From: Smith, Maxine [Maxine.Smith@lancashire.gov.uk]
Sent: 14 March 2013 13:24
To: Stephen Kilmartin
Cc: Sharples, Richard; Terry, Ben
Subject: Lawsonsteads
Attachments: Lawsonsteads Response 25.02.13.docx; Lawsonsteads farm whalley.pdf
 Stephen

Lawsonsteads, Ribble Valley BC Development (3/2013/0137)

Education Assessment 25th February 2013

Client: Commercial Estates Group			
Project: Whalley			
Title: Parameter Plan			
Status:			
Designed:	Drawn: HE	Checked: AR	
Scale: 1:1000@A1	Date: 1/02/13	Approved: AR	
Drawing No: PL1158.3.M.101			Revision: A

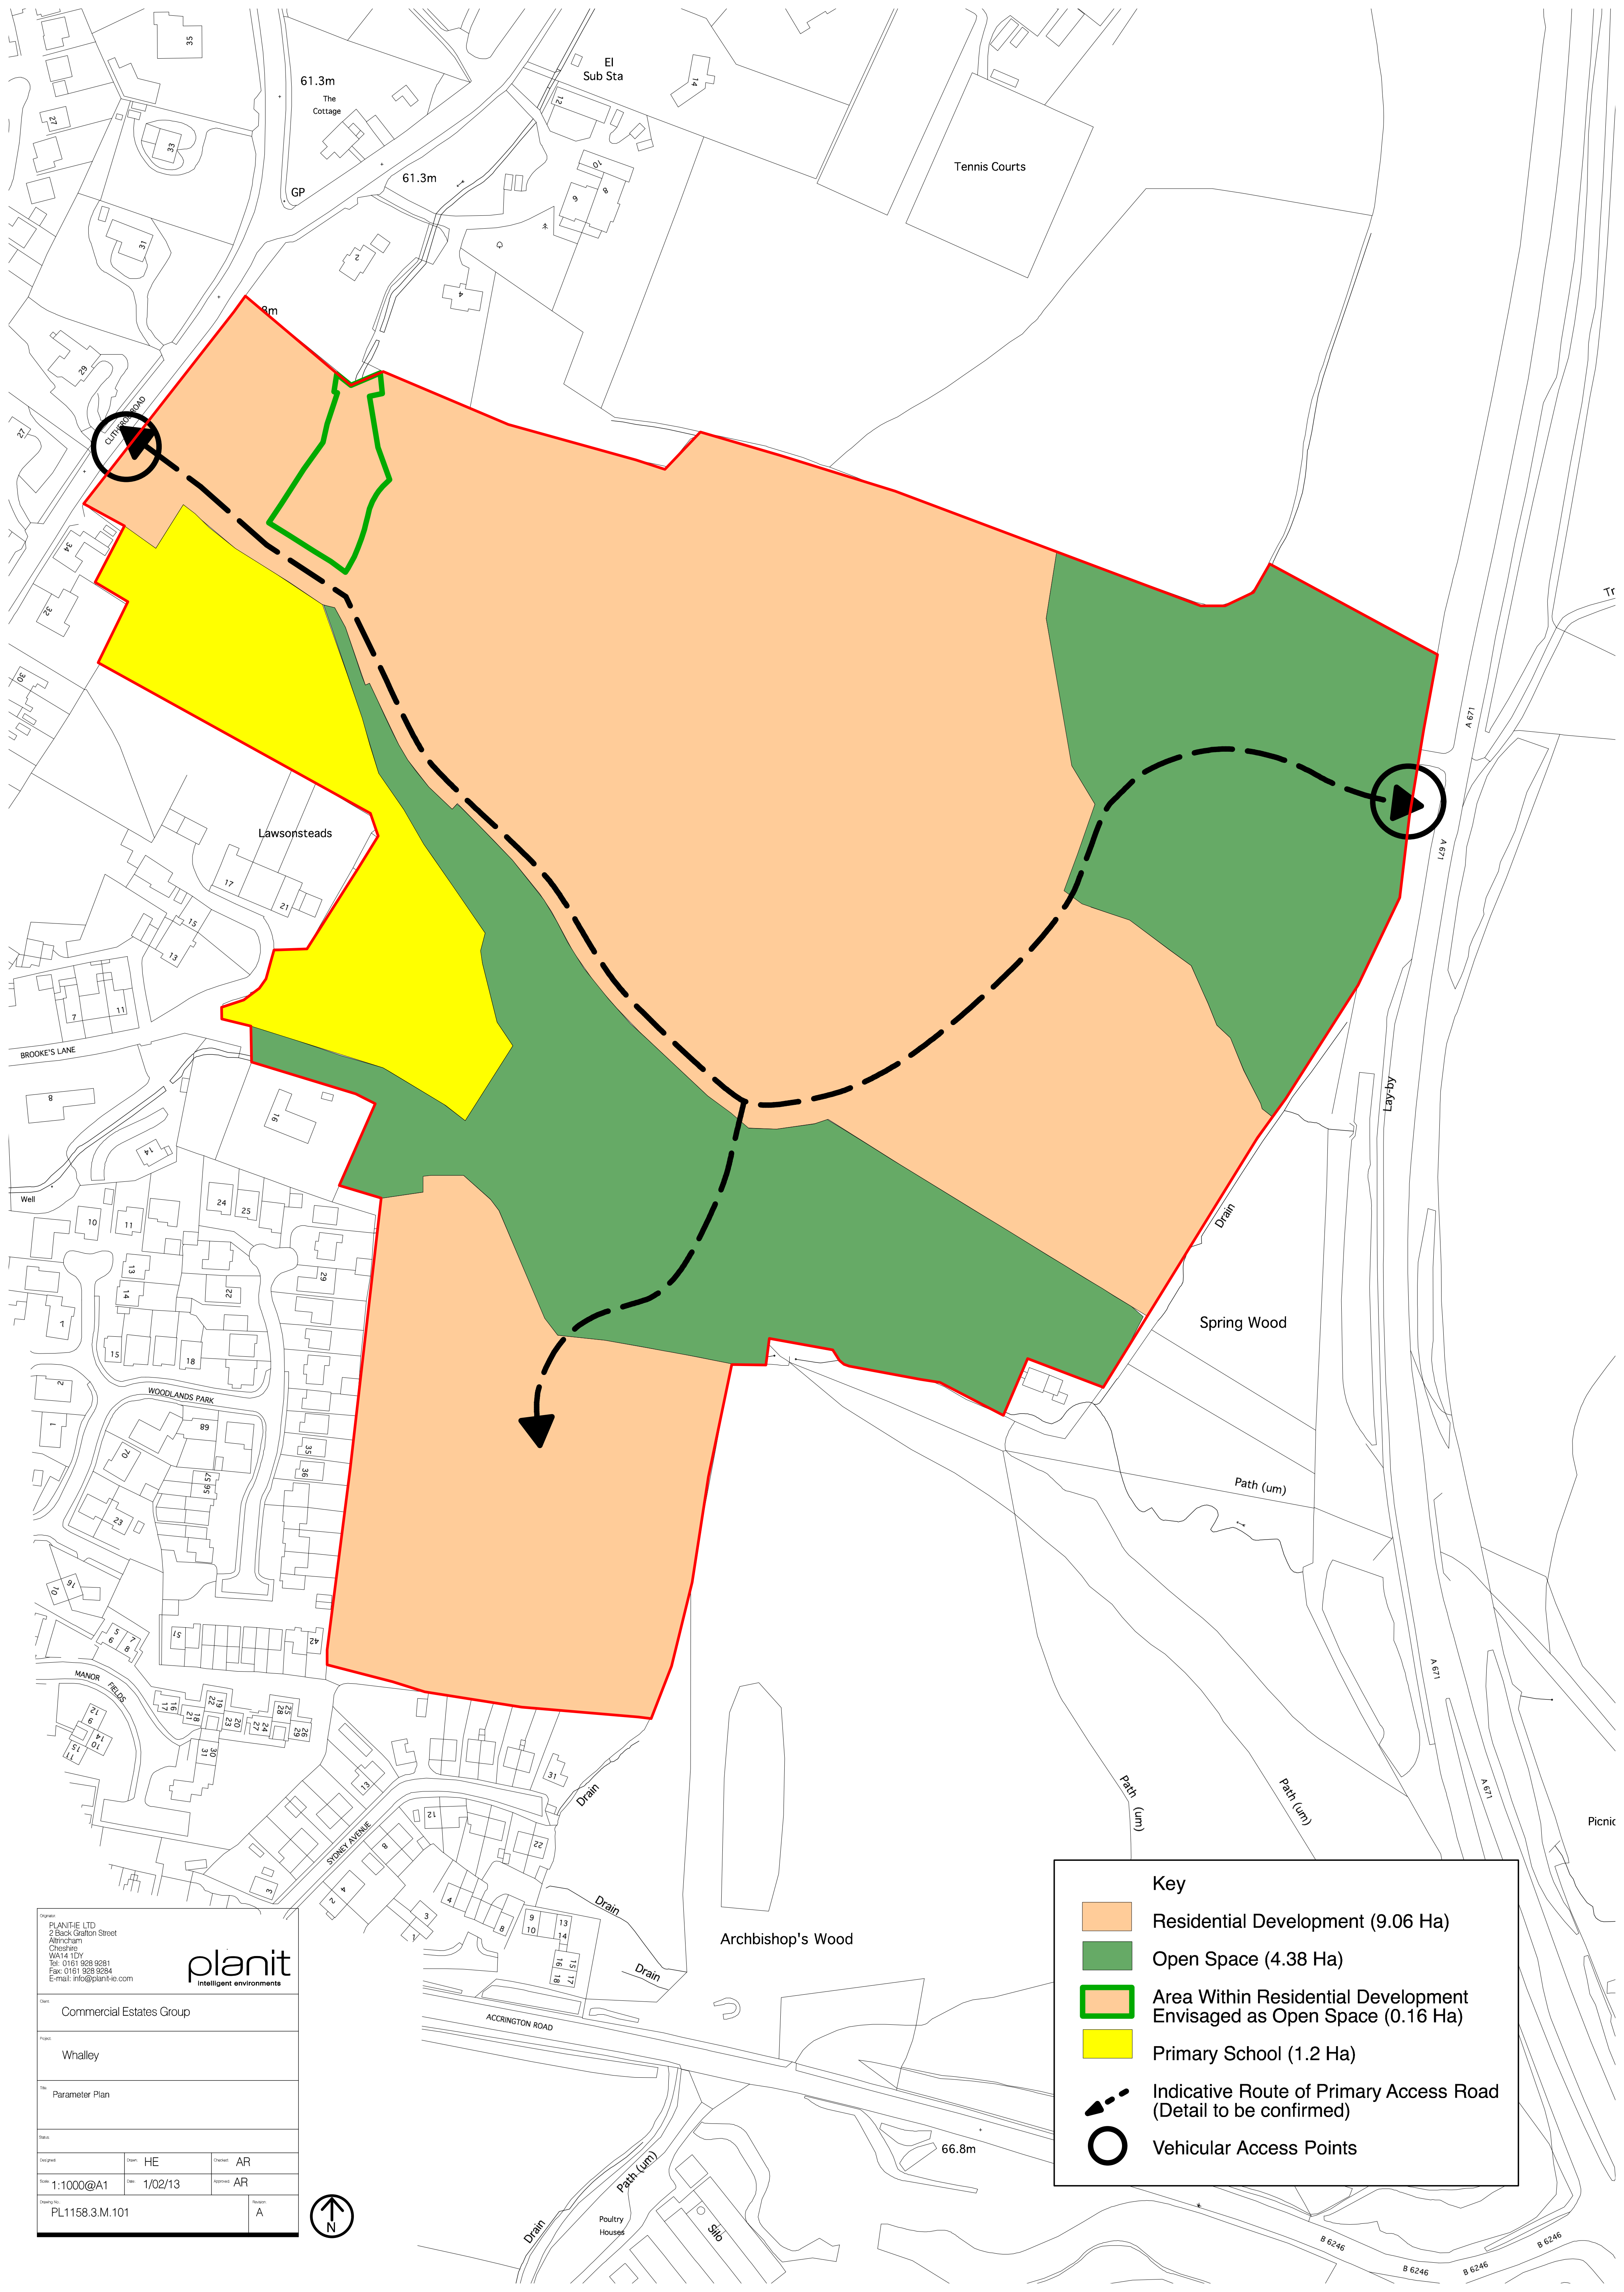
- The area identified as yellow on the original plan is unsuitable due to the restrictive site shape and being bounded by the brook. The most suitable position for a new school is shown in green on the attached pdf taking in to account the site visit was purely visual.

The area east of woodlands park could be ideal to use as a school site but with the drawing given to us, it showed a single road access to this part which we feel may cause difficulty with access.
